# **OXFORDSHIRE COUNTY COUNCIL'S RESPONSE TO CONSULTATION ON THE FOLLOWING DEVELOPMENT PROPOSAL**

**Application no:** 16/02446/F

**Proposal:** Erection of 297 residential dwellings (Use Class C3) comprising a mix of open market and affordable housing, together with associated works including provision of new and amended vehicular and pedestrian accesses, public open space, landscaping, utilities and infrastructure, and demolition of existing built structures and site clearance works.

**Location:** Heyford Park Camp Road Upper Heyford Bicester OX25 5HD.

GEOGRAPHIC SCOPE / JUNCTIONS TO BE ASSESSED

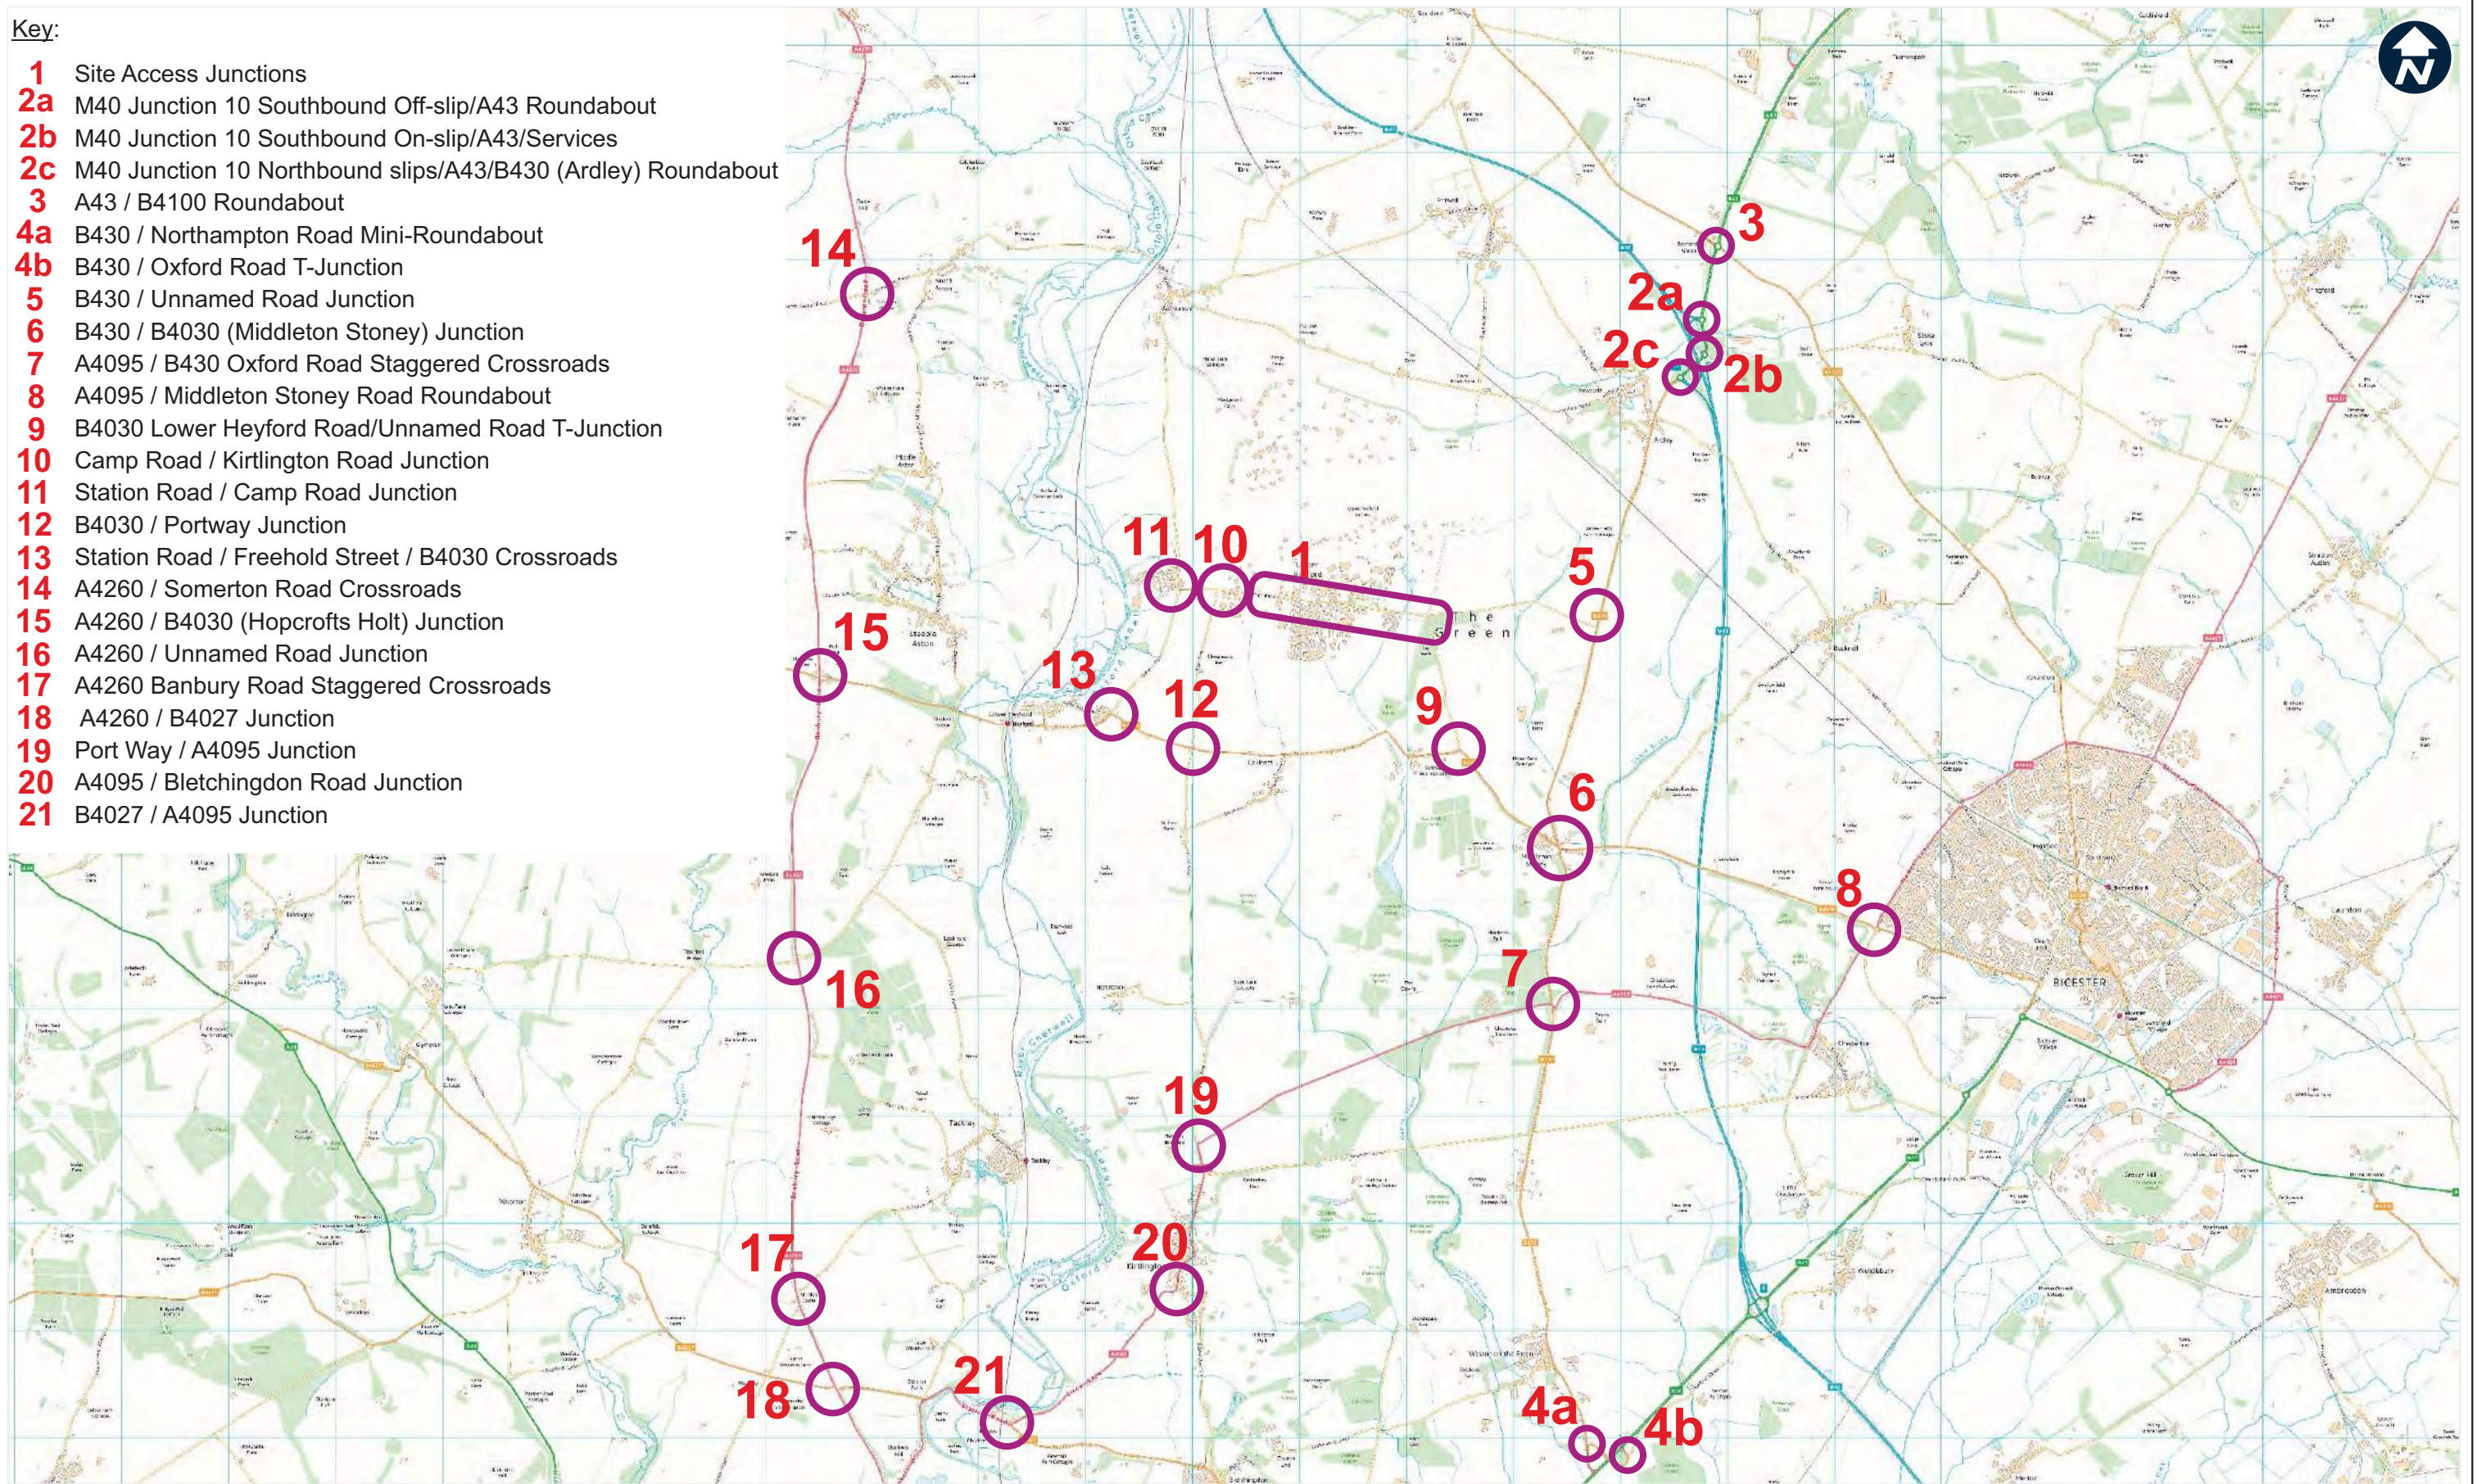
Section 6.7 presents the assumed traffic impact study area. This area is limited and does not include all of the junctions that the County would expect to see assessed and which were detailed in its meeting with the developer in 2016.

Paragraph 6.7.2 specifically excludes two junctions on the grounds that no development traffic passes through them. However since the trip distribution is not verifiable it is not certain that these junctions would carry no development traffic. It is also counter intuitive that these junctions would carry no development traffic given their proximity to the development site.

For the avoidance of doubt the County would expect to see the following junctions also included in the traffic impact study area **Reason for objection.**

- A4260 Oxford Road / Somerton Road / Aston Road;
- A4260 Oxford Road / B4030 Signalised Junction (Hopscroft Holt);
- B4030 / Station Road / Freehold Street;
- B4030 Lower Heyford Road / Port Way Staggered Crossroads;
- B4030 Lower Heyford Road / Camp Road.
